Appeal Decision

Appeal Ref: APP/R4408/D/22/3305257

5 Park View Road Staincross, Barnsley S75 6LD

- The appeal is made under section 78 of the Town and Country Planning Act 1990 against a refusal to grant planning permission.
 - The appeal is made by Mr Richard Foster against the decision of Barnsley Metropolitan Borough Council.
 - The application Ref 2022/0495, dated 10 May 2022, was refused by notice dated 15 July 2022.
 - The development proposed is a two-storey extension to side.
-

14 PROPOSED NEIGHBOURS SIDE ELEVATION
1 : 50

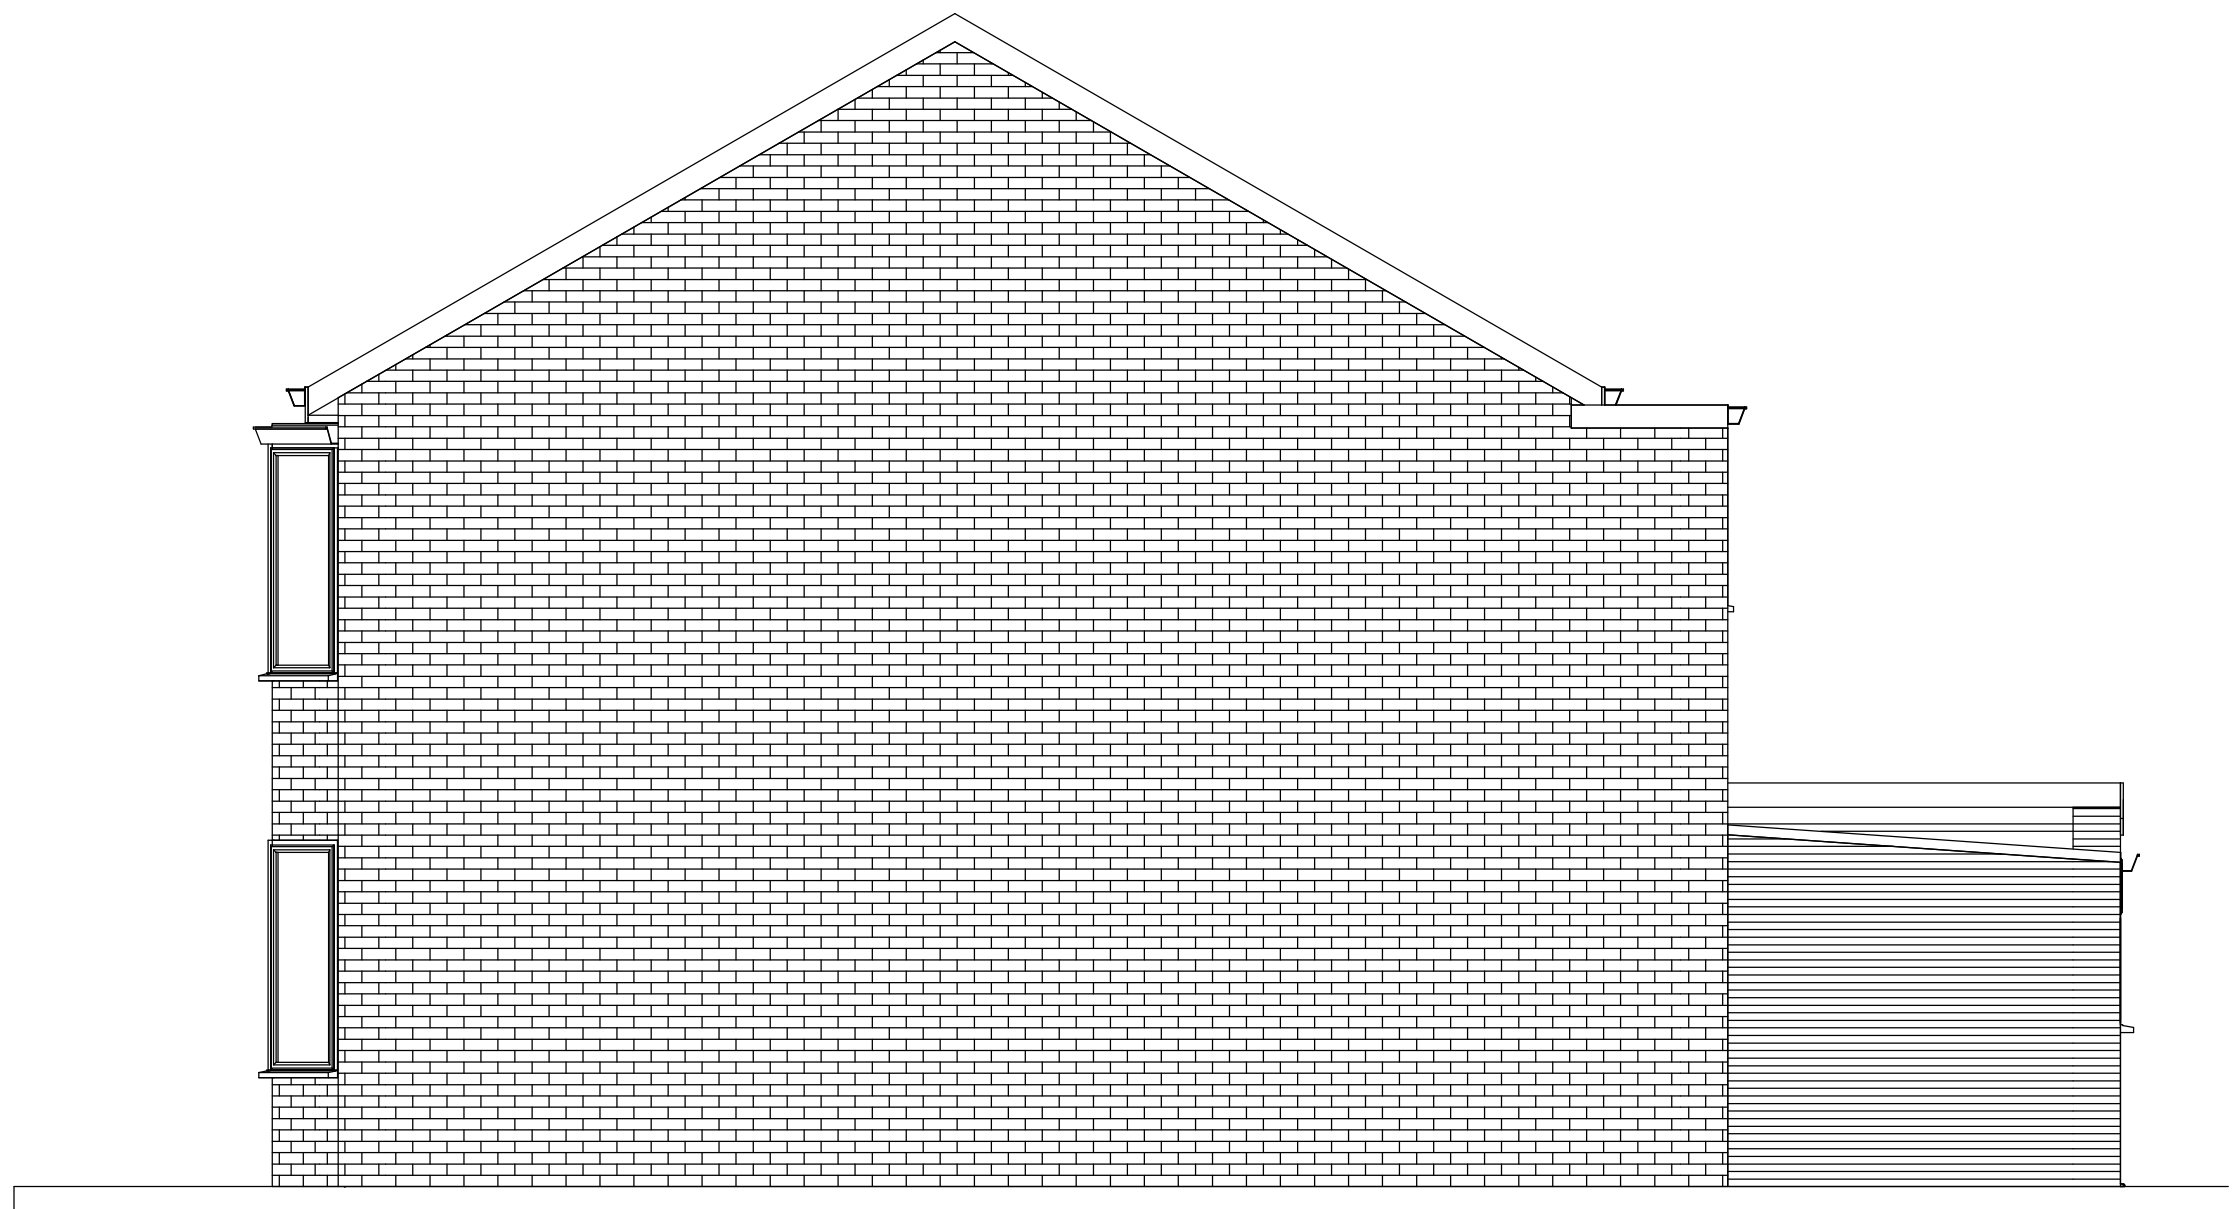
5. The proposed two-storey side extension would fill the width of the driveway of No.5 and would be sited almost up against the joint boundary. The adjacent bungalow at No.4 has a bathroom and a bedroom window within its side elevation facing the side of No.5. The windows of No.4 can be seen well above the top height of the fence and therefore the occupants would clearly be able to view the side elevation of the proposed extension. The two-storey height,

depth and proximity of the proposed extension would enclose a section of the joint boundary with a high blank brick wall where it faces existing windows.

6. Notwithstanding that the bathroom is obscurely glazed, from the bedroom window the neighbouring occupants would be able to see towards the back. Even if the side wall of the proposed extension would not extend across the full width/extent of the bedroom window the presence of the proposed extension would still loom in close proximity to this single aspect bedroom. The occupiers of No.4 would look out in close proximity to a tall blank brick elevation significantly higher than the fence. It would result in an oppressive form of development harmfully affecting their outlook.

7. As demonstrated in the photographs taken by the appellant and as I observed on my site visit the proximity of No.4 and No.5 to each other and their orientation indicates that the proposed development would not significantly affect sunlight or cause extensive overshadowing. However, the overall two-storey height and proximity of the proposal would create a narrower gap between the side windows of No.4 which would be likely to result in a darker environment in the bedroom by obscuring more of the sky and daylight.
